THE ROCK COMMERCE CENTER GRADING AND EROSION CONTROL PLANS

PCD FILE NO. PPR2329

GRADING AND EROSION CONTROL PLANS

THE ROCK COMMERCE CENTER
SITE DEVELOPMENT PLAN
GRADING PLAN

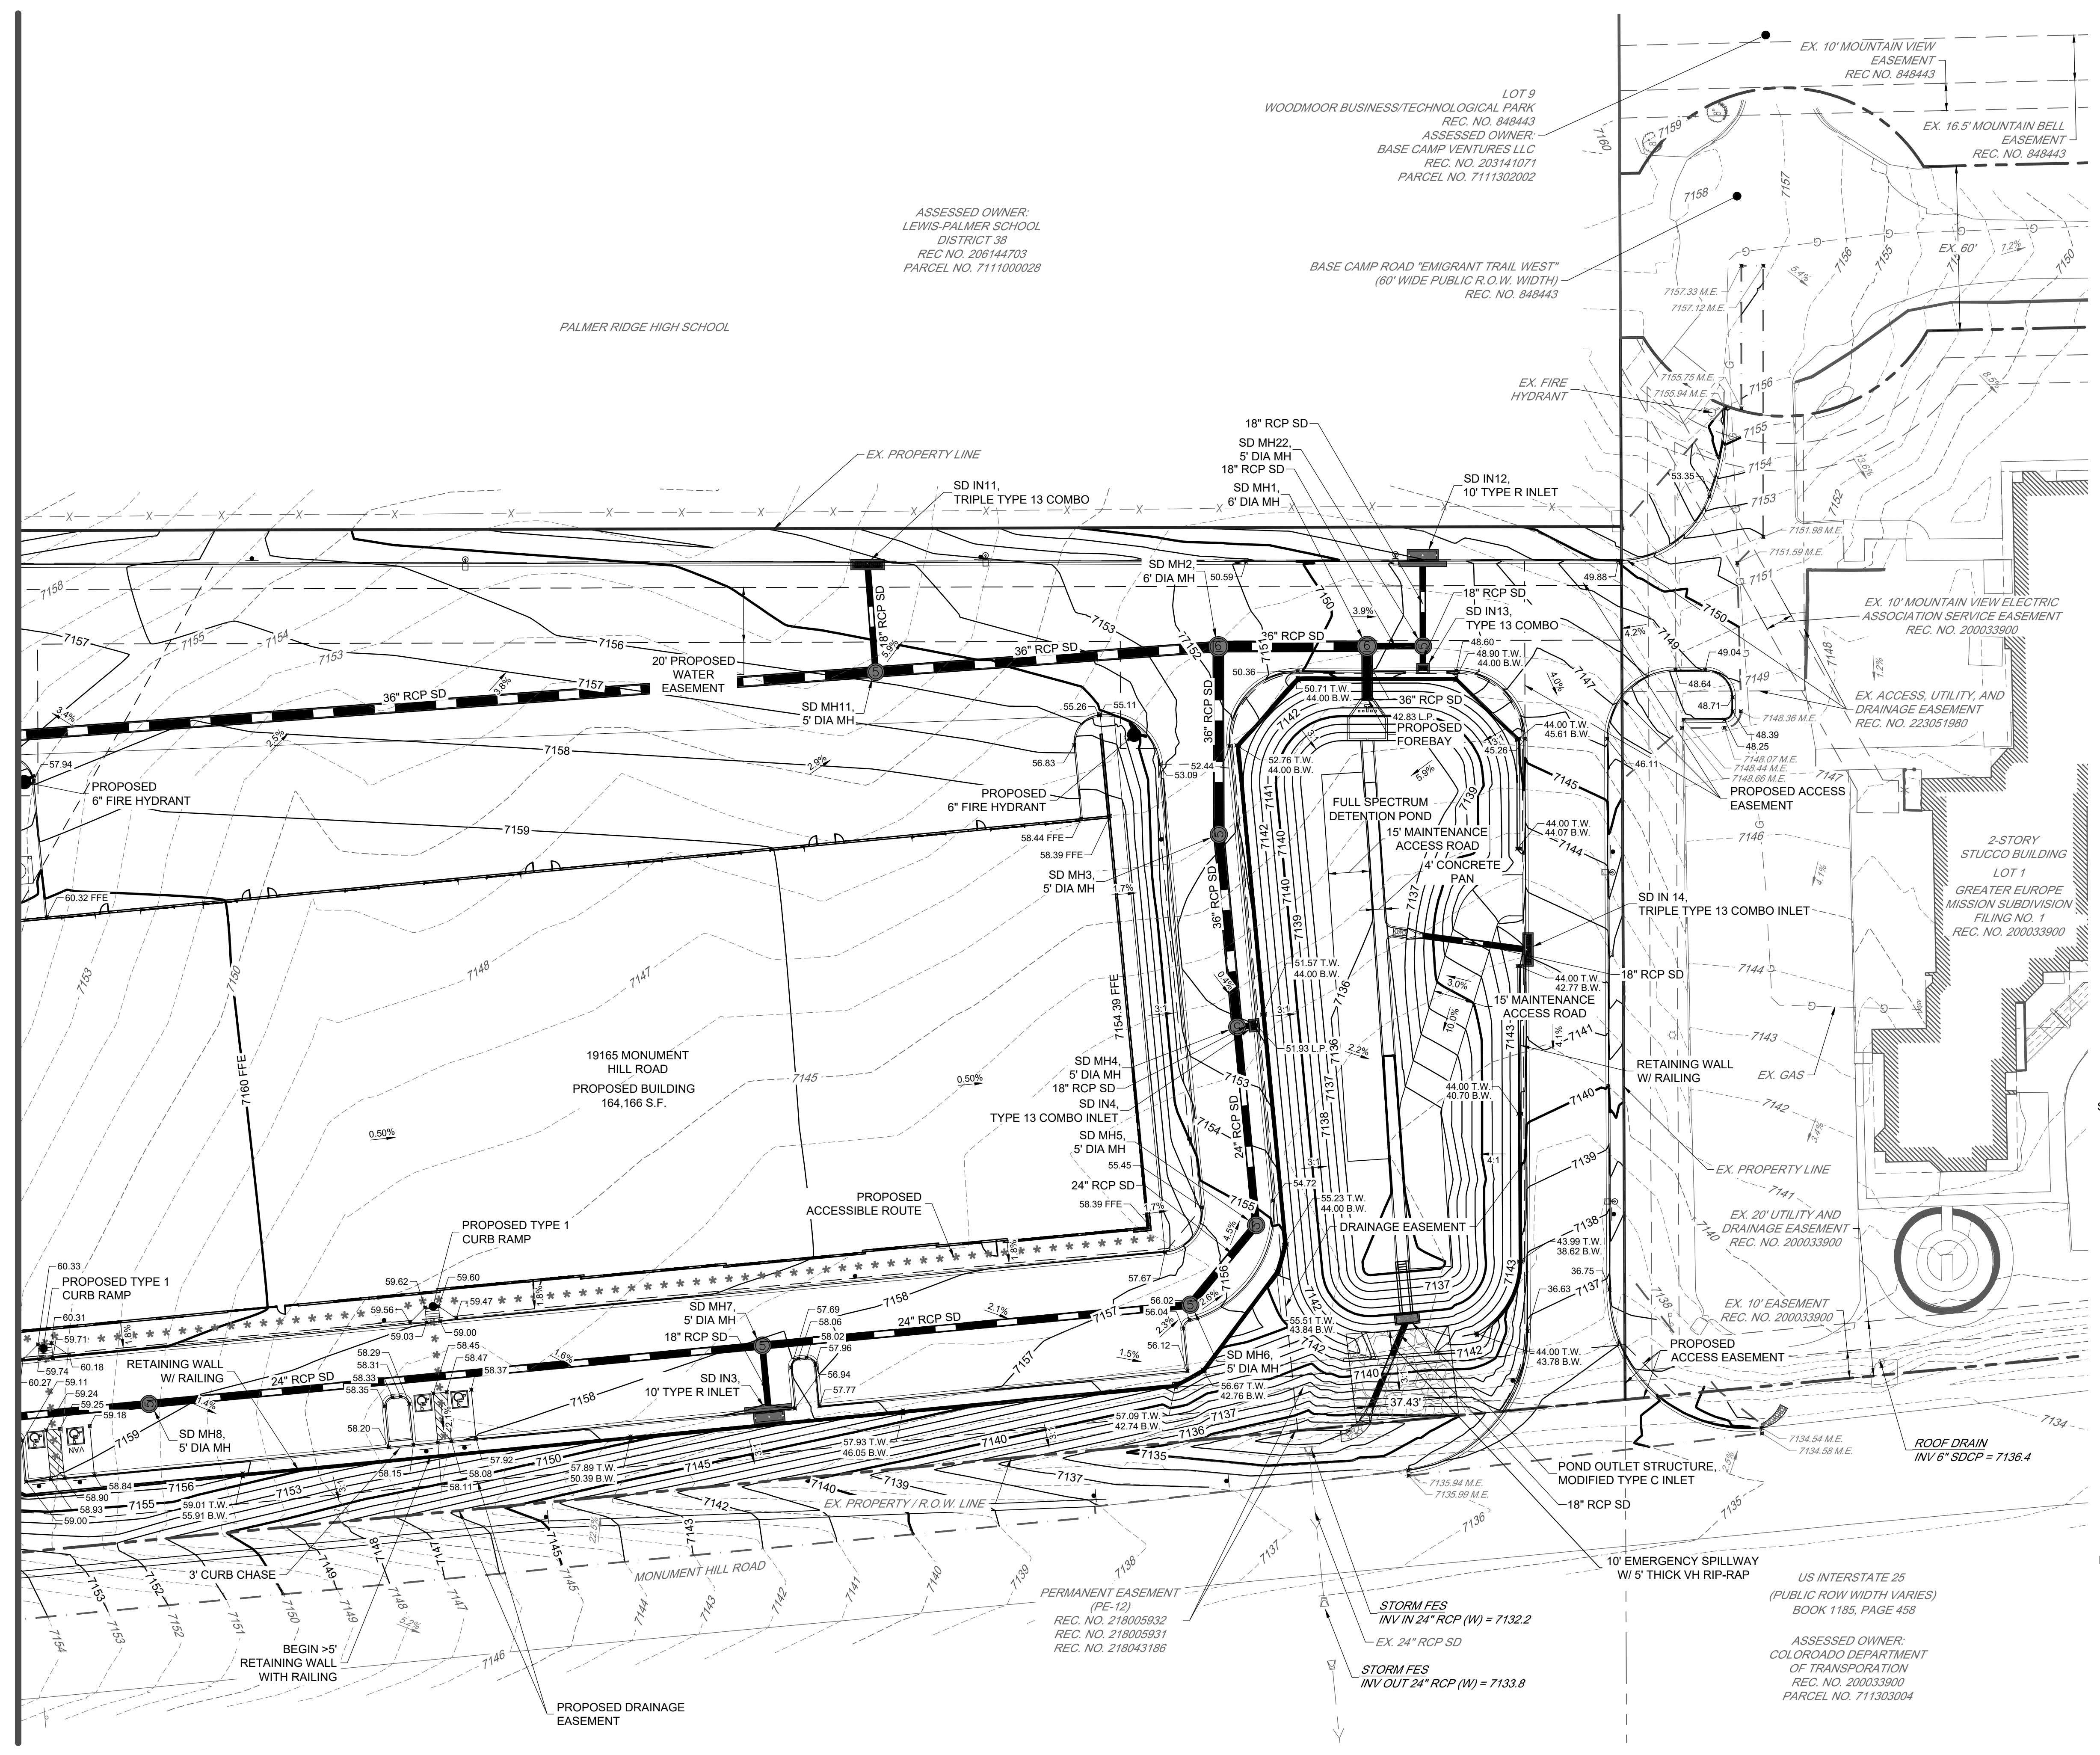
Provide riprap type, depth, and thickness.

Label riprap outlet protection

This riprap was labeled with type, width, depth, and thickness.
